Office of Environment & Heritage

Your reference: MP07_0103-Mod 2
Our reference: Doc12/36534
Contact: Rachel Lonie, 9995 6837

I refer to your email dated 29 August to the Office of Environment and Heritage (OEH) regarding Modification 2 for the Apex Energy NL Gas Project (MP07_0103). The modification seeks to extend the expiry date for the Approved Part 3A project to three years from commencement of drilling of the first bore hole.

RE: ACCESS TO PROPOSED GAS BORE HOLES A113, A115 AND A117

Figure 1. Borehole Locations

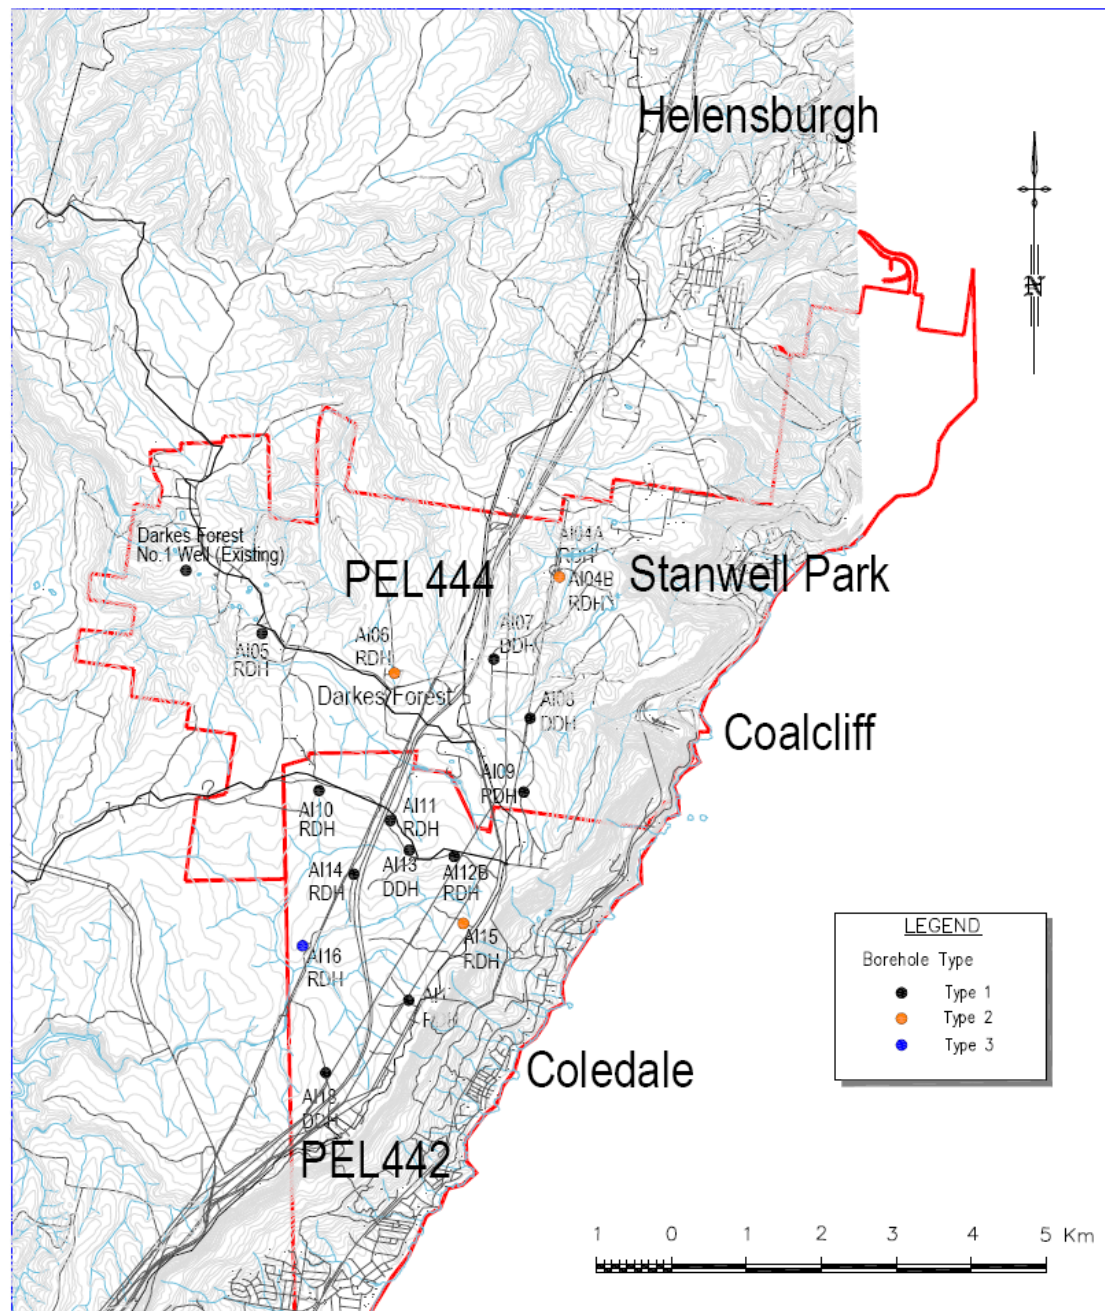
Advice has been sought from OEH's Regional Parks and Wildlife Group. It appears that boreholes A113, A115 and A117 are on OEH land. OEH previously advised the Proponent (Attachment 1) that access for exploration purposes or prospecting activity for proposed boreholes A113, A115 and A117 could not precede without the approval of the relevant landholder, in this case the Minister for the Environment, as the boreholes were proposed to be drilled within the Dharawal State Conservation Area (SCA). Since this letter was written, a large part of Dharawal SCA has been gazetted as Dharawal National Park and the remainder as Dharawal Nature Reserve, with a small section only remaining as SCA.

The change in reservation status occurred following consultation with the Department of Mineral Resources and with the approval of the Minister administering the Mining Act 1992. As a result of the changed reservation status an extension or a renewal of the Part 3A approvals for those particular areas is no longer permissible under the *National Parks and Wildlife Act 1974* (the Act). Sections 41 and 54 of the Act state that prospecting and mining are prohibited in national parks, heritage sites and nature reserves except as expressly authorised by an Act of Parliament. OEH therefore advises that it would be unlawful to undertake exploration at proposed boreholes A113, A115 and A117. For this reason, the modification, if granted, must exclude these boreholes from any approval.

OEH recommends that DoP&I ensure that the location of any exploration work is outside national park and nature reserve areas. Further, if any activity is within an SCA the Proponent should be advised that they will need separate approval under NPWS Act. A map layer called NSW National Parks and Wildlife Service (NPWS) Estate can be found at <http://mapdata.environment.nsw.gov.au/DDWA> by searching under "estate" in the keywords.
